Application no: **3/2023/0488**

Address: **The Old Printworks 4a and 6a Back York Street Clitheroe BB7 1LT**

Proposal: **Change of use to three dwellings including demolition and rebuild of brick extension to create three storeys.**

The Local Highway Authority have viewed the plans and highway related documents and have the following comments to make:

Former Castle View Print Works
Back York Street
Clitheroe BB7 1LT
Existing Elevations 1:100 @ A3
Showing Demolition Scaffolding

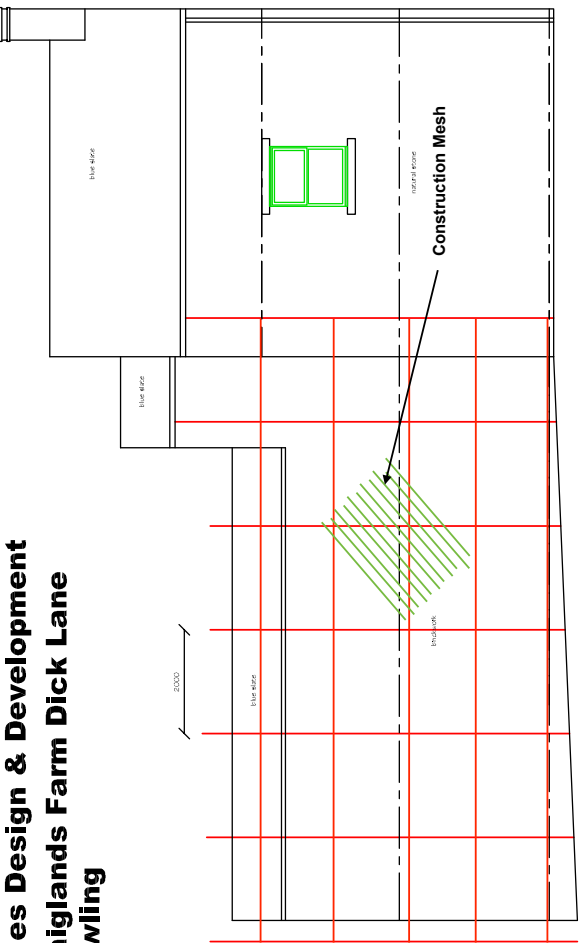
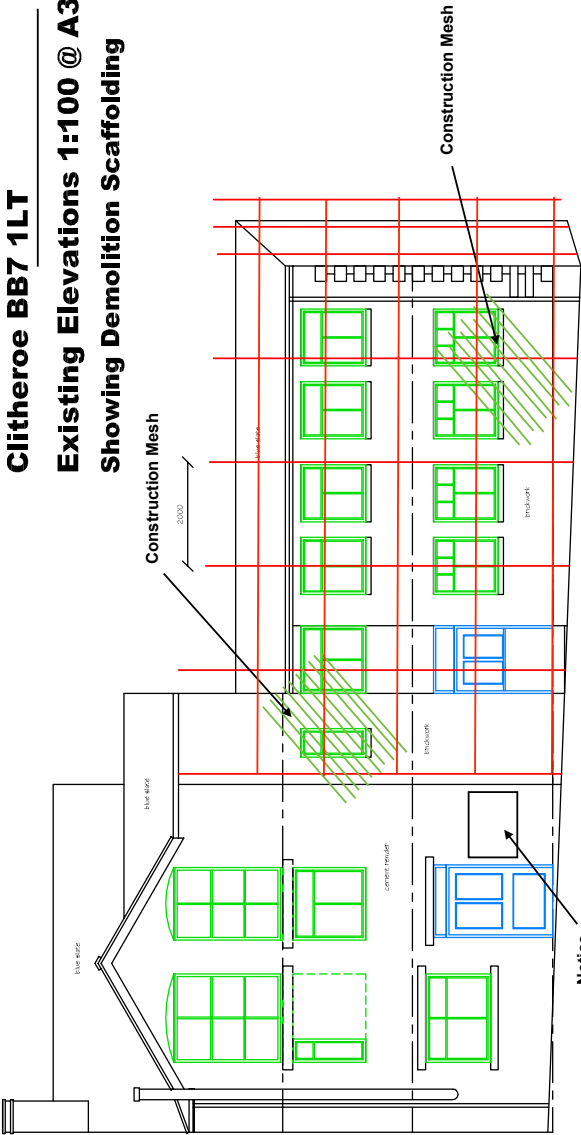
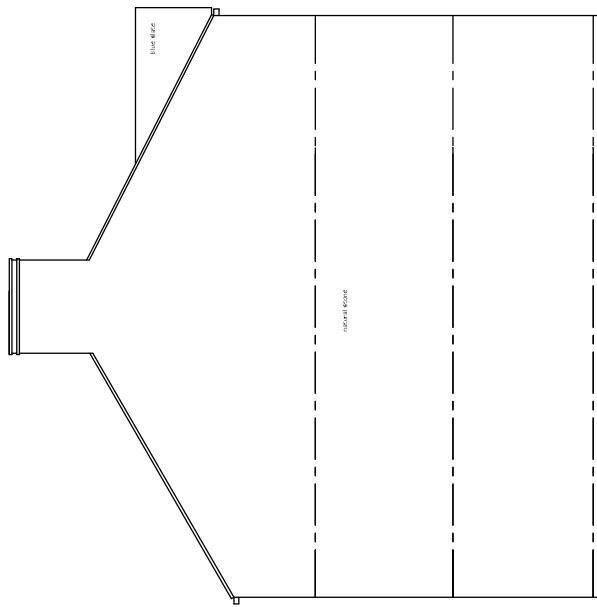
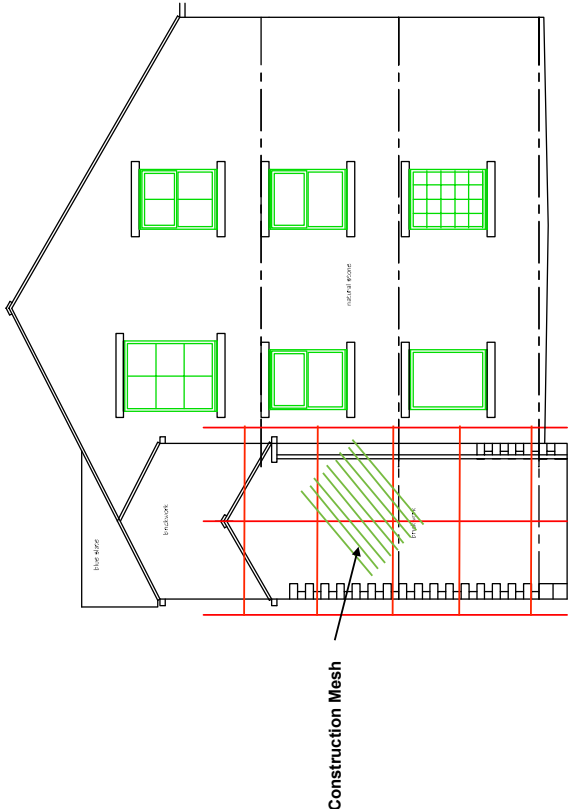
- Where will the proposed hoardings, scaffolding and skips be located and for how long will they be at the site? How will access to neighbouring dwellings, the Grand car park and Kingdom Hall of Jehovah's Witnesses be maintained for pedestrians, vehicles and emergency vehicles while these items will be at the site?

- Where will the telehandler be stored when it's not in operation? How will it get to and from the site?
- What measures will be put in place to protect pedestrians and vehicles during the construction phase of the development? The LHA are unable to accept a subcontractor being located on Back York Street, adjacent to Kingdom Hall checking for any movement of pedestrians from either Albion Street or York Street to ensure their safety in case of falling debris. Instead, the site needs to be adequately protected to prevent this from happening.

Proposed Floor Plans 1:100 @ A3

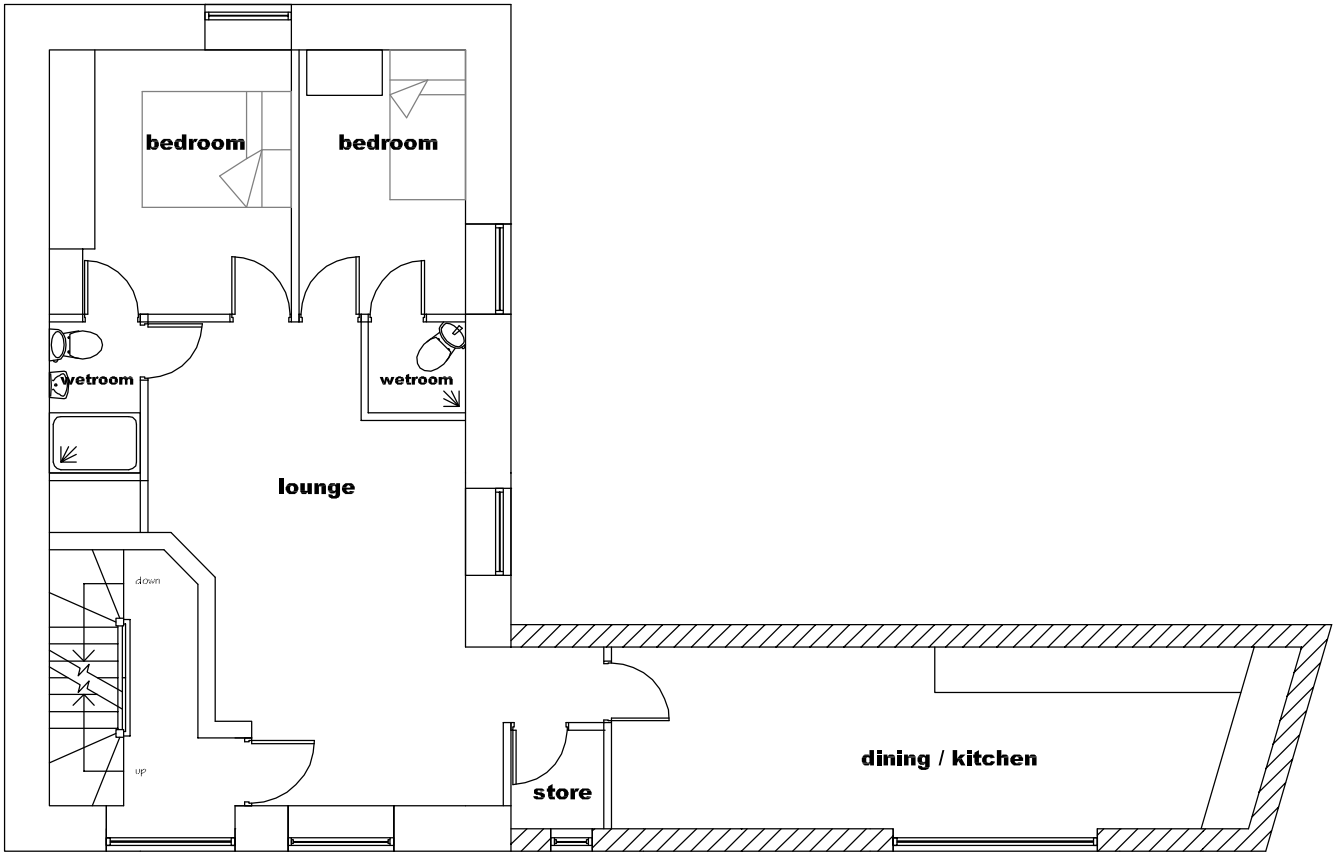
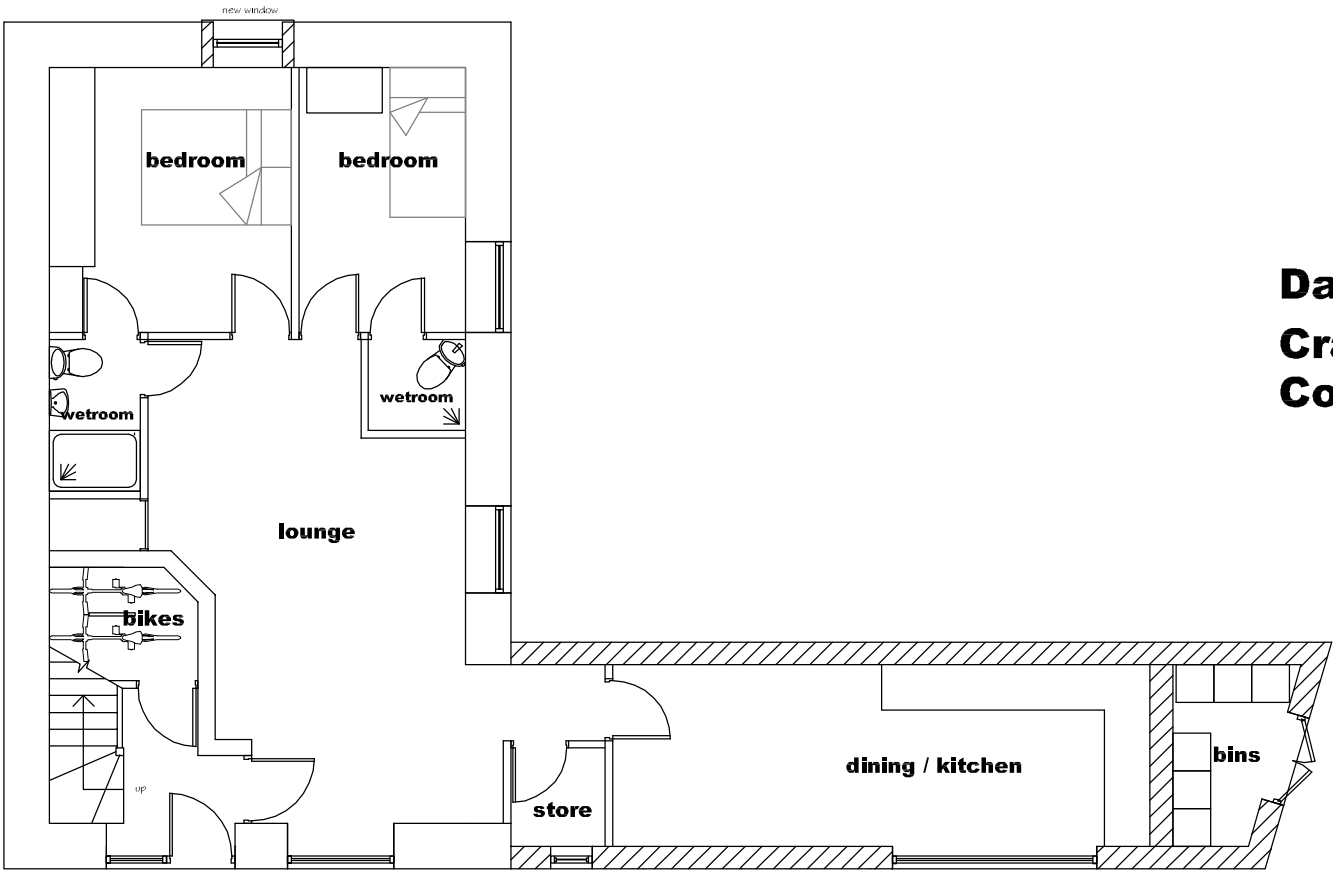
However, due to the shortfall in parking, the LHA will request that a minimum of one cycle space per flat is provided. These facilities should therefore be shown on a revised plan.
